WEST SUSSEX COUNTY COUNCIL CONSULTATION

TO:	Arun District Council FAO: Simon Davis
FROM:	Highways, WSCC
DATE:	29/04/2021
LOCATION:	Land Adjacent to The Gun Post, Clyde Road, Felpham, PO22 7AH
SUBJECT:	FP/84/21/PL 1 No. additional self-contained beach hut with sleeping accommodation. This site is in CIL Zone 4 (Zero Rated) as other development.
DATE OF SITE VISIT:	N/A
RECOMMENDATION:	Advice
S106 CONTRIBUTION TOTAL:	£N/A

Proposed Site Plan
Scale 1 : 200

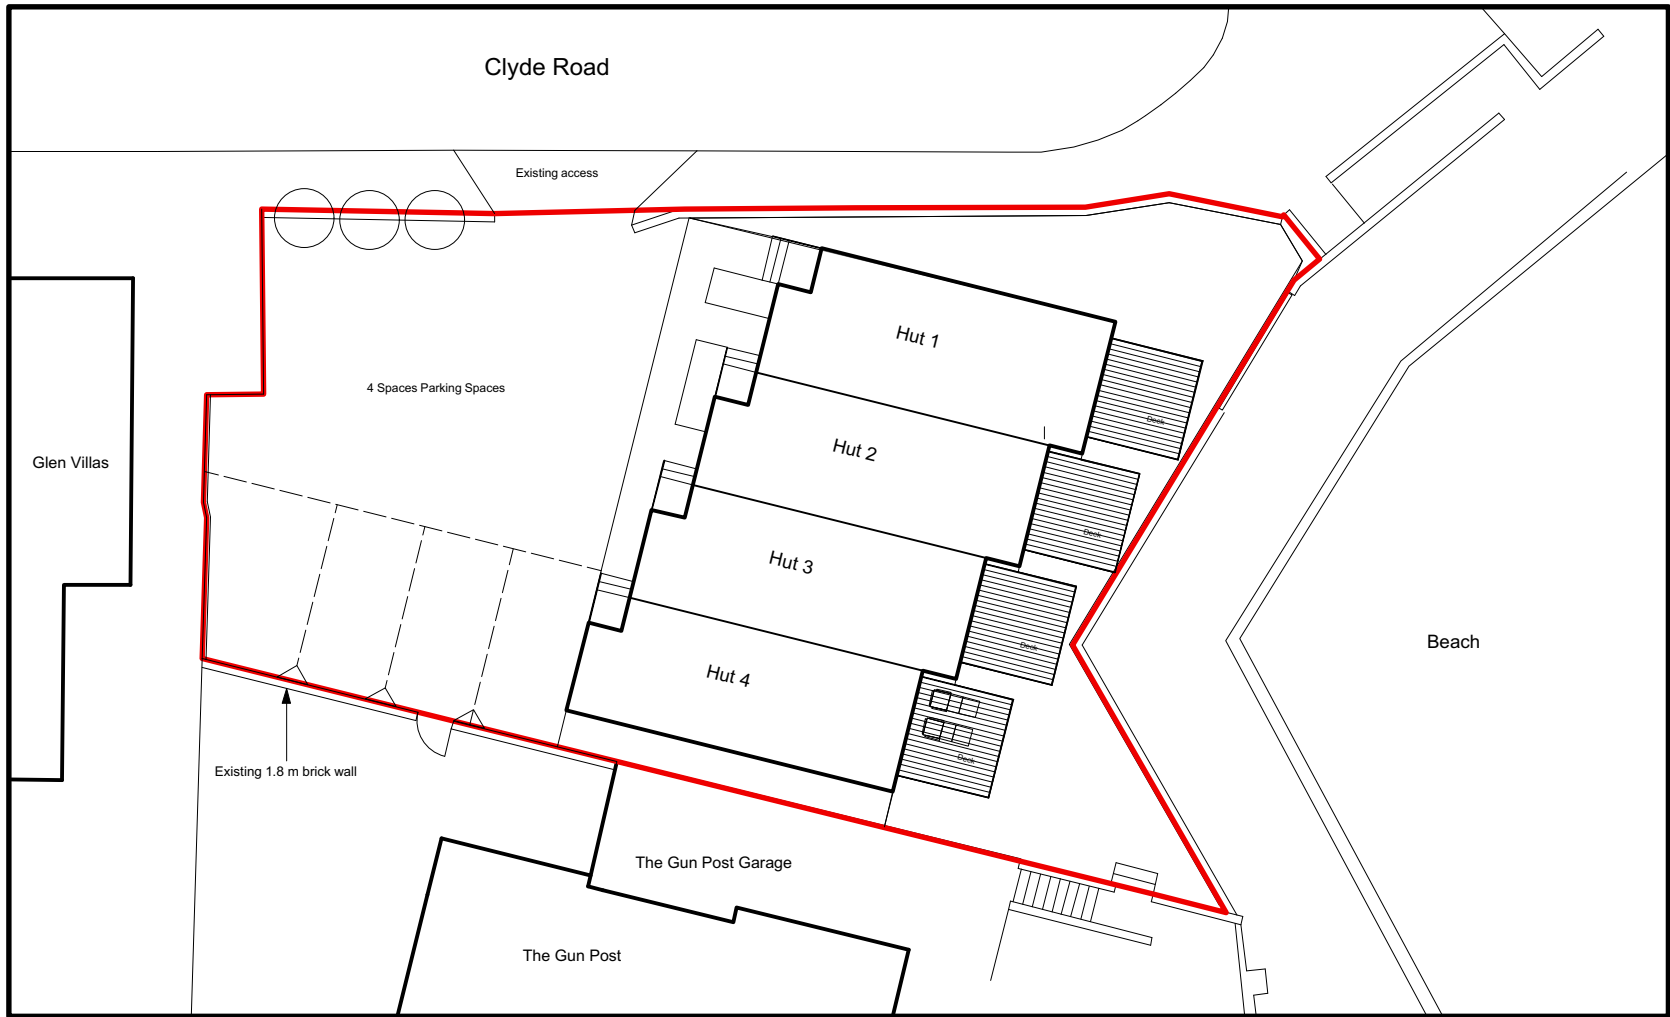
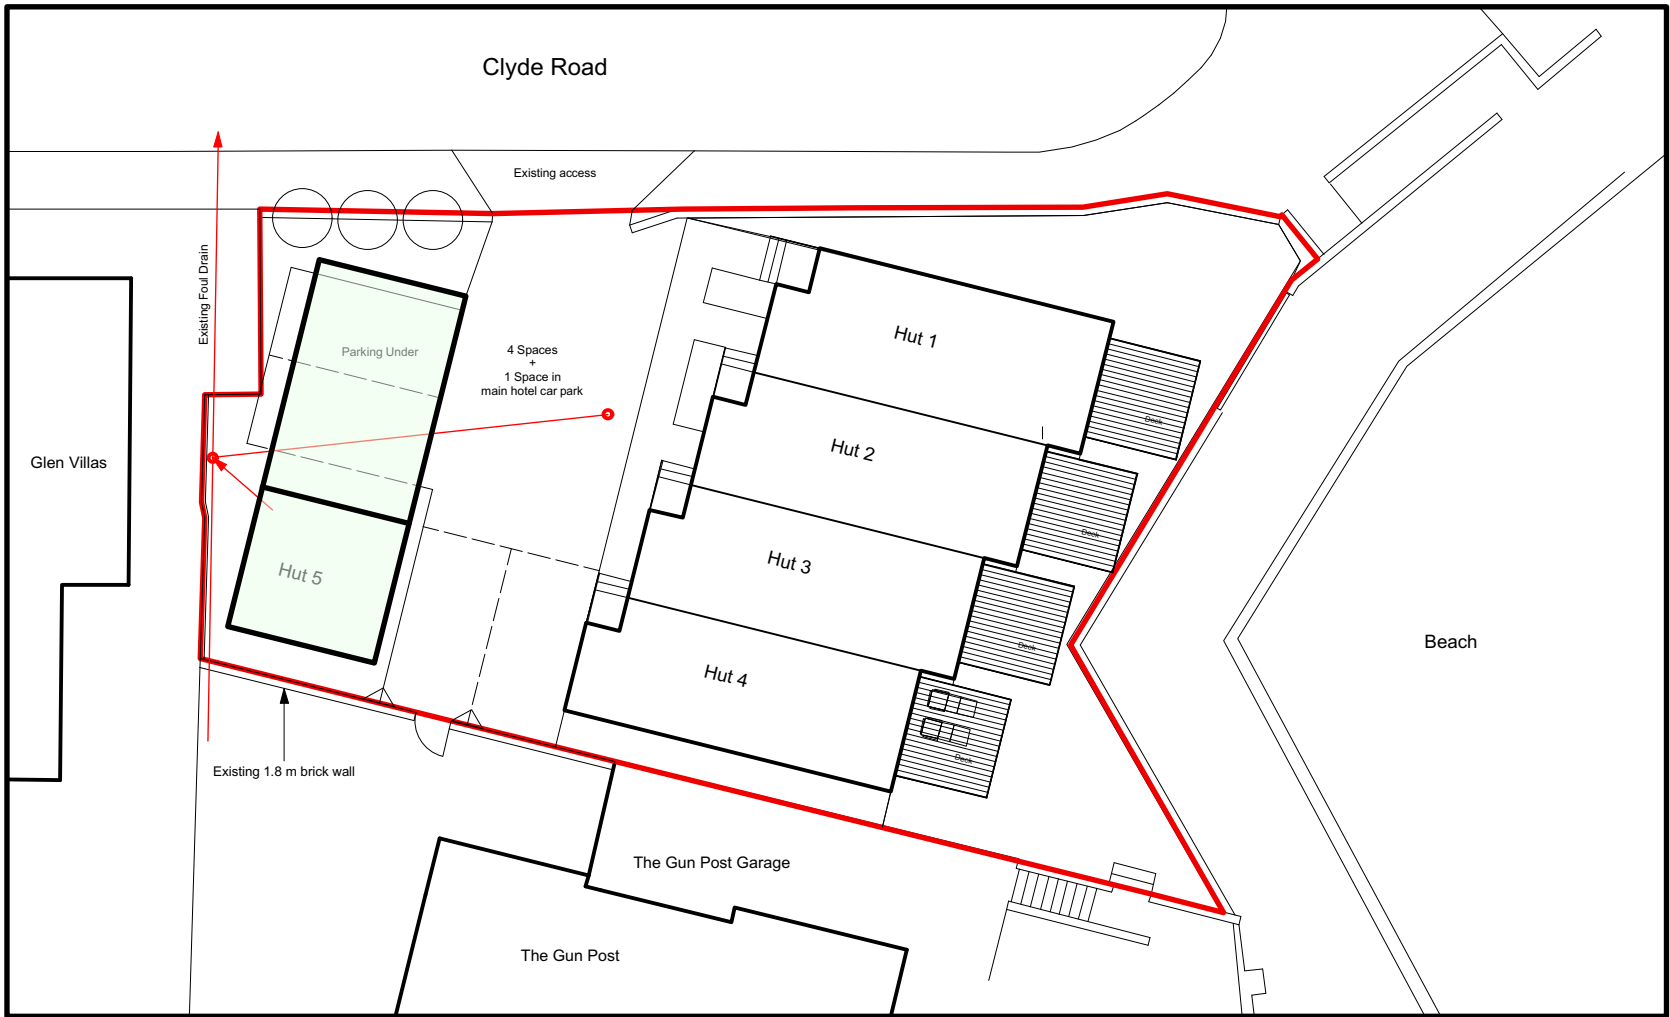
The applicant proposes to relocate two of the existing parking bays into under-croft parking, located underneath the proposed beach hut. The two remaining parking spaces will remain unchanged, with a fifth parking space located within the main car park. From inspection of the plans, the proposed parking bays are suitably sized.

The LHA does note that on-site turning may require a multi-point manoeuvre, due to the location of the proposed beach hut. As per MfS 8.3.51, parking bays require at least 6m of space behind them to ensure that a car can manoeuvre in an out of a parking bay at 90 degrees. As such, cars turning on-site may have to use a multi-point manoeuvre or exit the site in a reverse gear. Although, given the slow speed, no-through nature of Clyde Road, this is not anticipated to result in a highway safety concern.

No part of the development shall be first occupied until the car parking has been constructed in accordance with the approved site plan. These spaces shall thereafter be retained at all times for their designated purpose.
